## MEMORANDUM

<b>DATE:</b>	March 10, 2021	<b>RWDI REFERENCE #:</b> 1904405
<b>TO:</b>	Anthony Witherdin	Director, Key Sites Assessments - DPIE
<b>FROM:</b>	Kevin Peddie	<b>Email:</b> kevin.peddie@rwdi.com
	Michael Pieterse	michael.pieterse@rwdi.com
<b>RE:</b>	<b>Wind Environment Conditions – City of Sydney Review Response Waterloo Metro Quarter – Building 2, Communal Open Space</b>

LEVEL 22 | LANDSCAPE PLAN

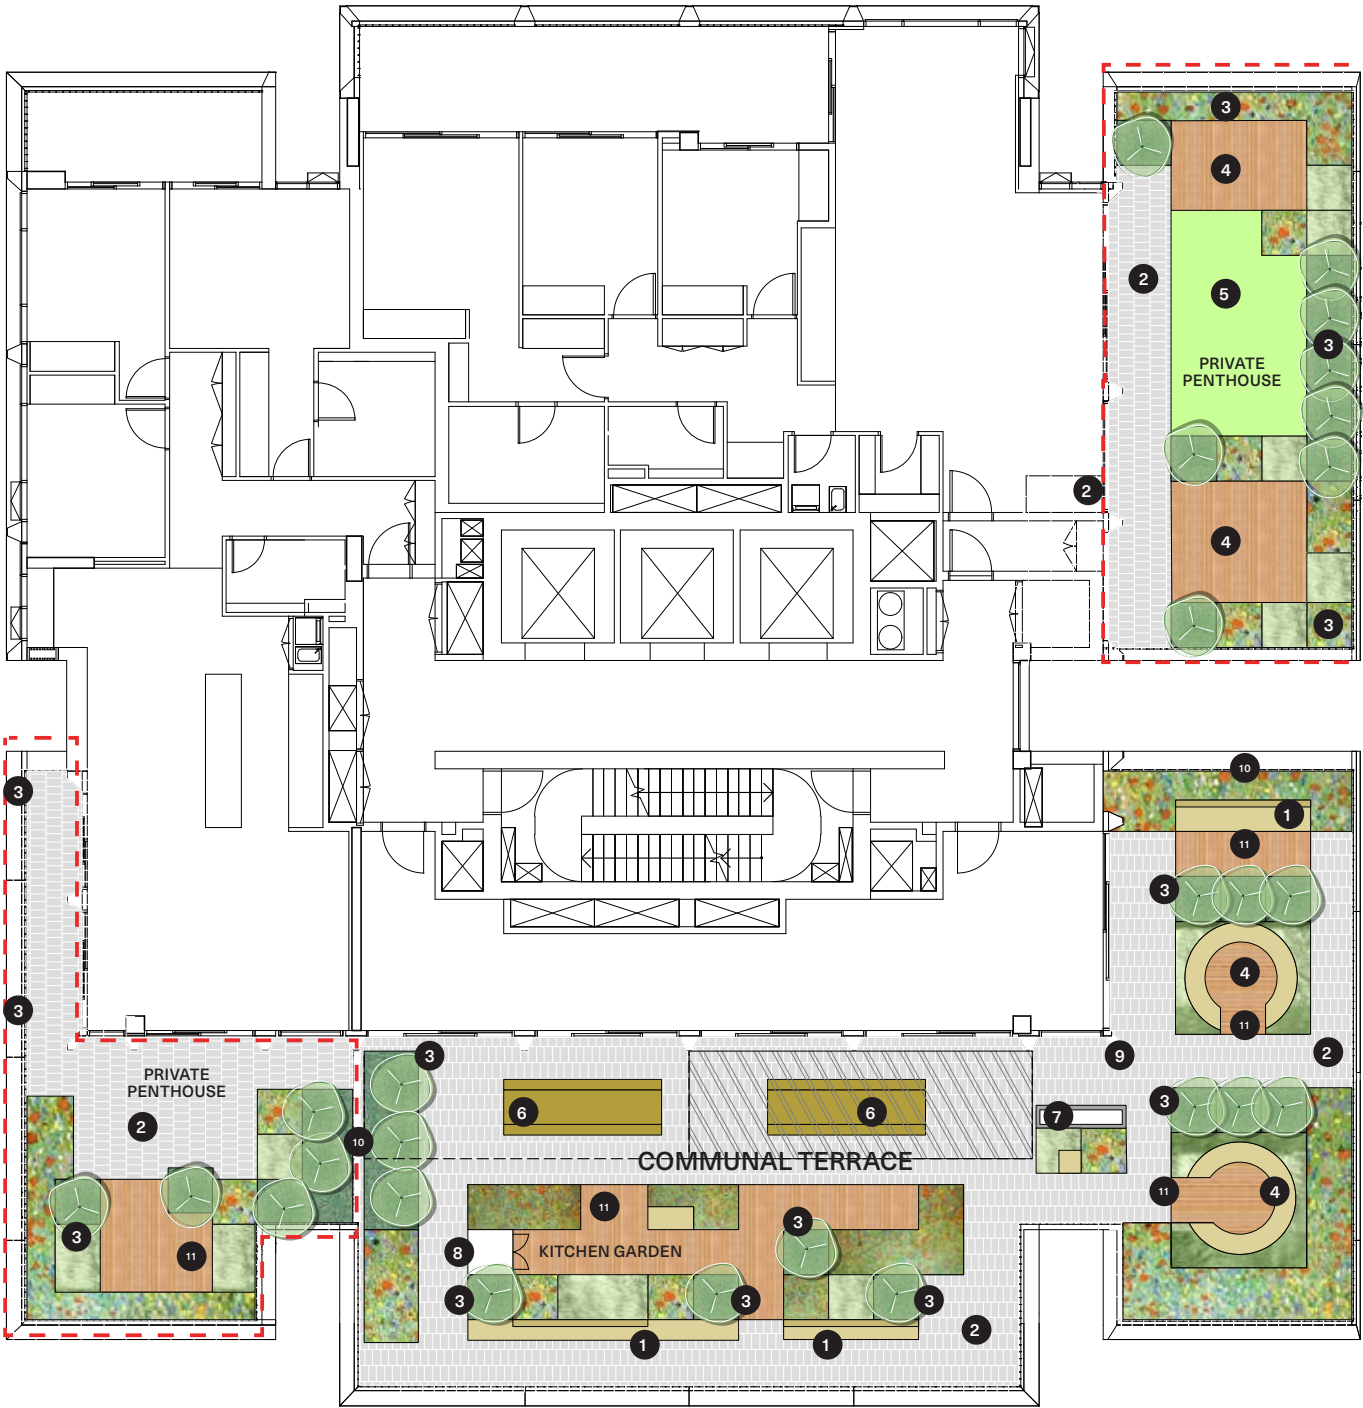
*Communal open space - Communal outdoor space is underprovided at 186sqm on level 22. According to the application, this equates to 7.5% of the site area, in contrast to the minimum 25% minimum recommended under Objective 3D-1 of the ADG. The wind analysis concludes that the terrace only achieves 'walking' comfort criteria in summer, and 'standing' conditions for the winter period. Neither is acceptable – the communal open space should be suitable for 'sitting' activities.*

Modelling undertaken and noted in the above figure included only the balustrade and pergola structure noted in the architectural drawings, without any consideration of the landscape design. The following figure shows the proposed landscape design of the communal space, which includes notable landscaping at the northern and southern areas. These will be beneficial in assisting to buffet the local wind effects, improving the percentage of time that sitting conditions are provided for residents using this space.

The wind conditions for the Level 22 communal terrace on Building 2 is noted to be located in an elevated position with exposure to the prevailing winds in all directions in the current context. Consideration was made by the design team during the process to ensure that this space felt like an outdoor environment which provided suitable conditions without feeling like a location with high screens around the perimeter.

Comment is noted from the City of Sydney that this area will experience walking comfort conditions in the summer months and standing during the winter months. It is worthwhile noting that the entire rooftop area will satisfy the standing criteria during the summer months for at least 89% of the time. Sitting conditions will be satisfied for at least 66% of the time during the summer months and at least 72% of the time during the winter months. The below figure provides a breakdown of the percentage of the time that the sitting and standing criteria will be achieved for the communal open space, which is extracted from the detailed wind tunnel study report.
